**One Carrington Street Mod 9 (SSD-5824-Mod-9)
Request for Additional Information**

I refer to your Response to Submissions (RTS) for One Carrington Street Mod 9 (SSD-5824-Mod-9). The Department has reviewed the RTS and requests the following additional information:

Office Level 09
Shell House Level 09

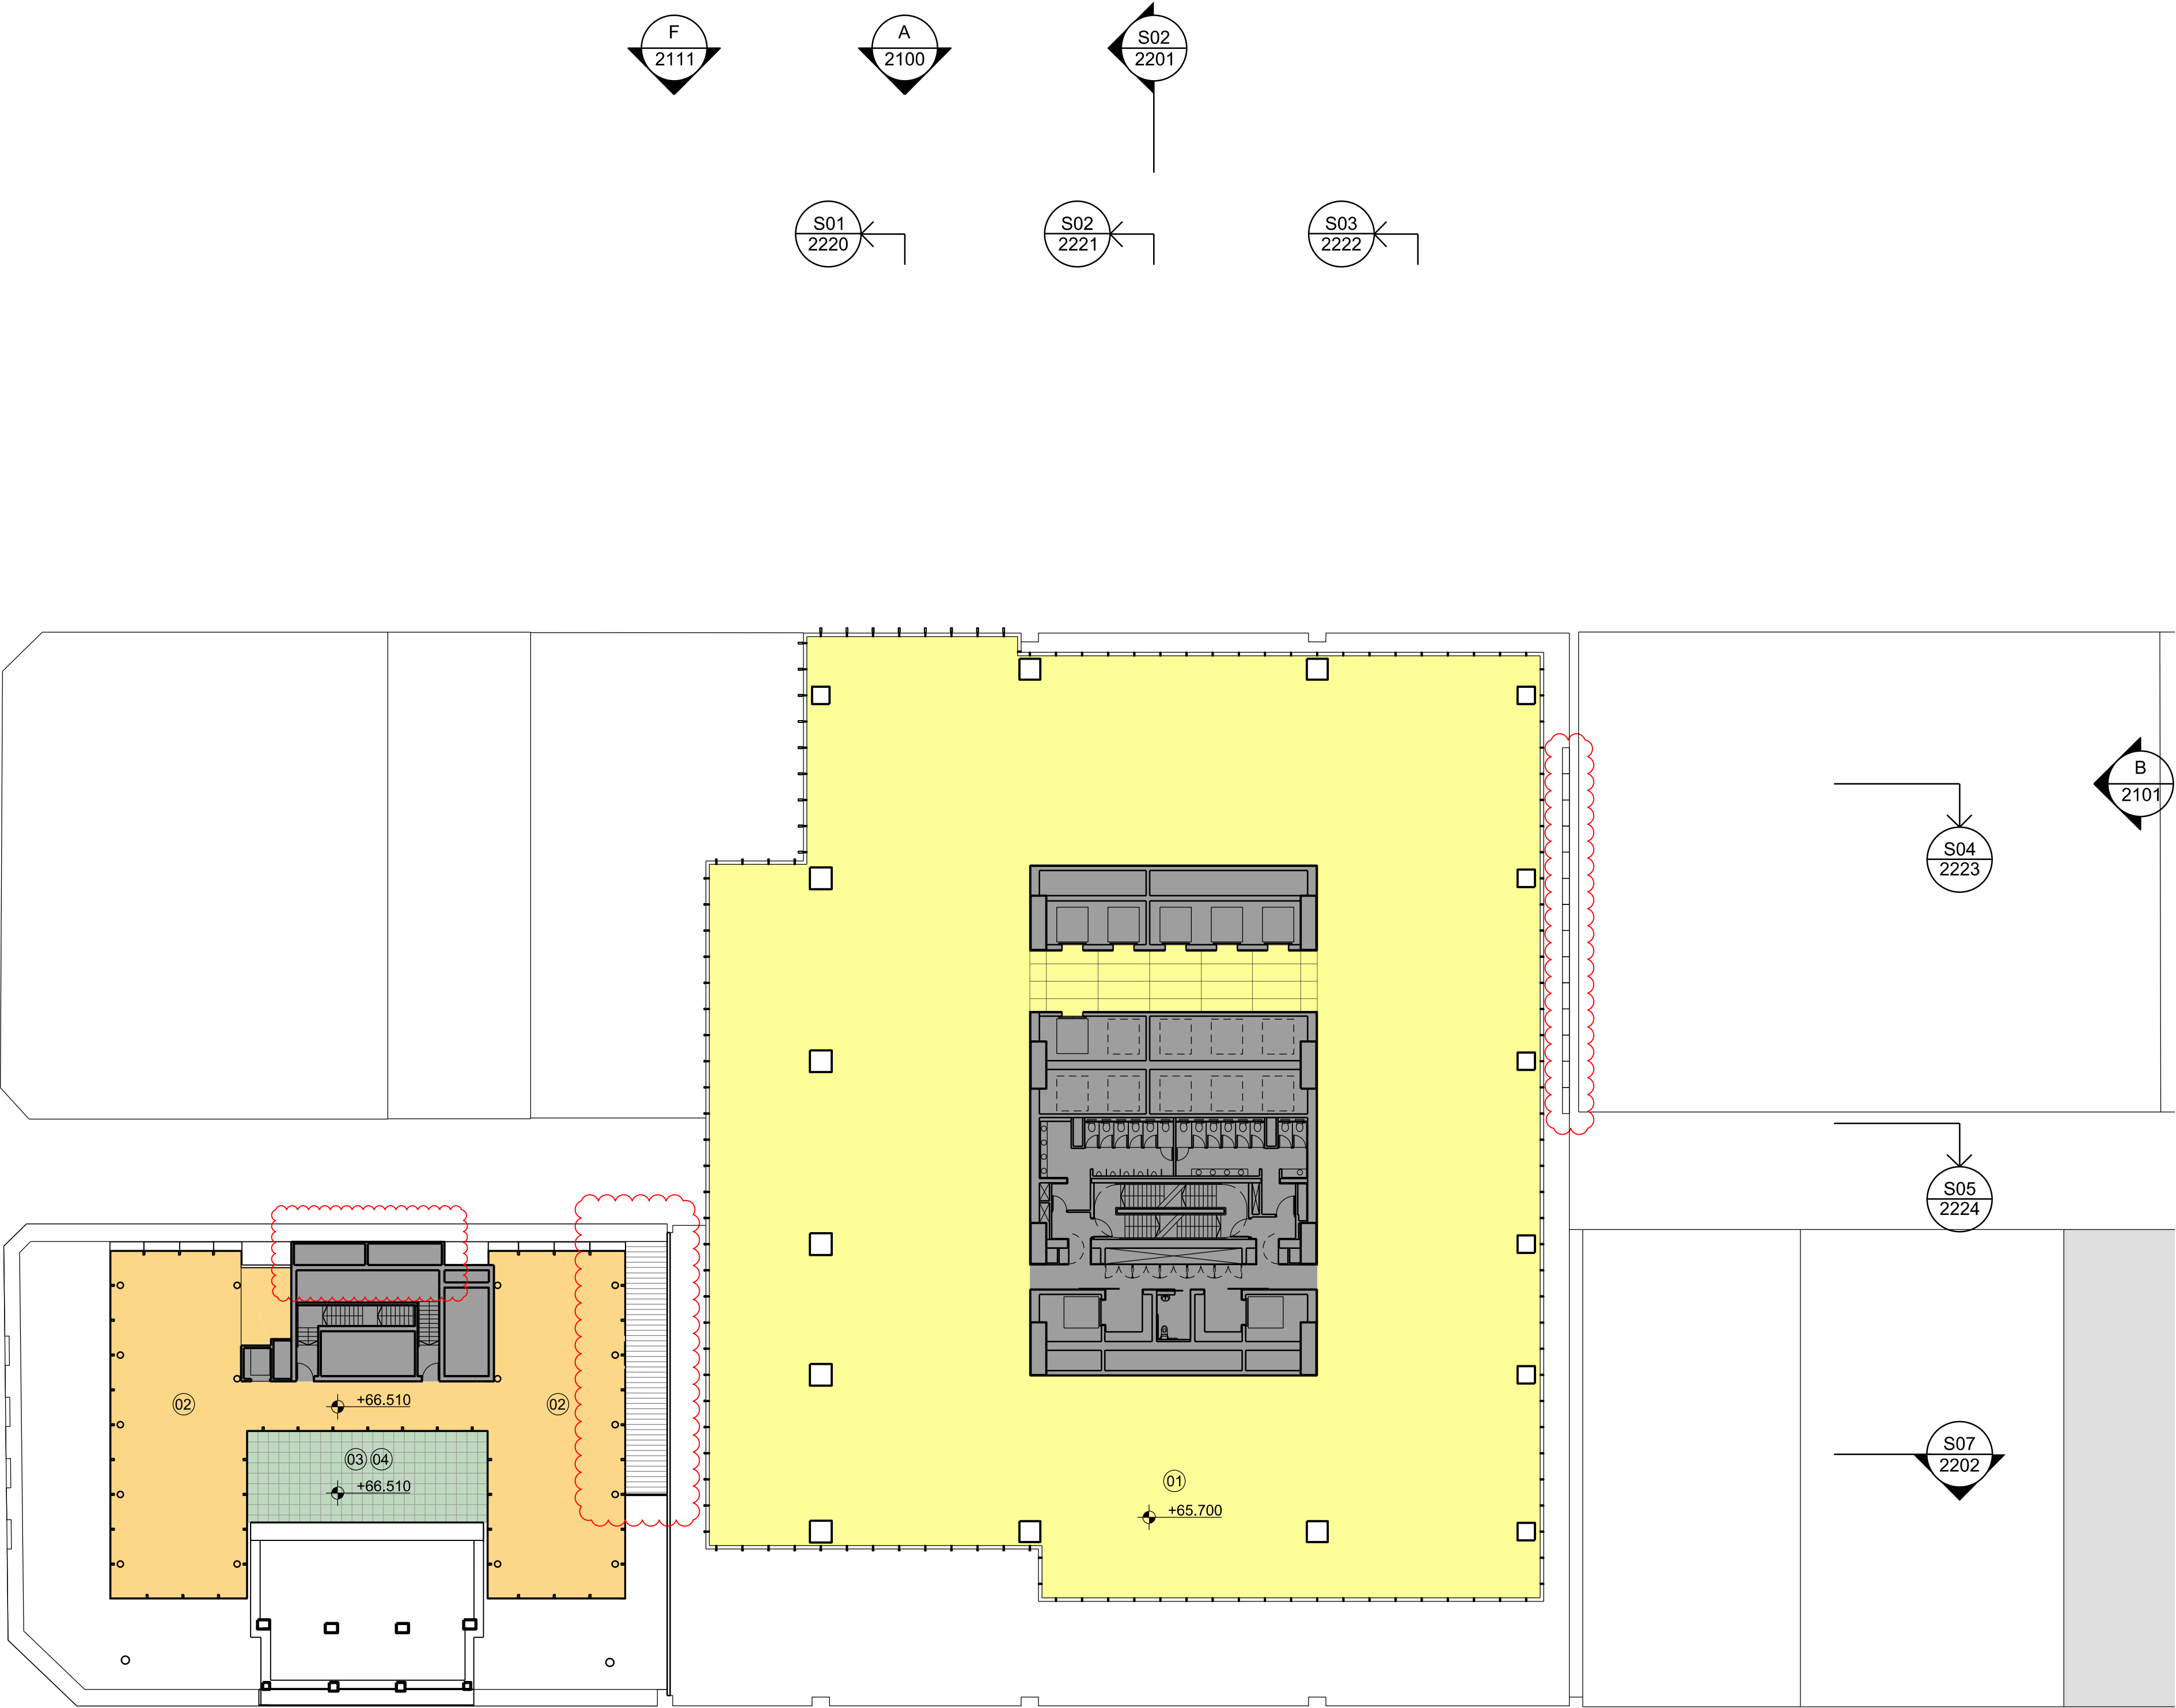
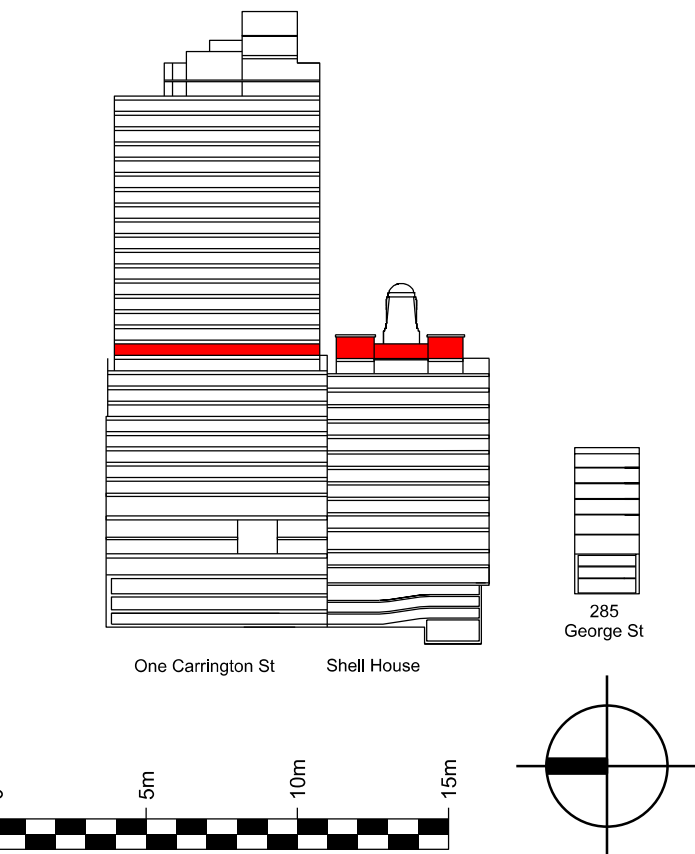
- please confirm if the aluminium screening proposed for Level 09 has been removed as part of the modification application. If not, please amend the architectural plans to reinstate the approved aluminium screening.
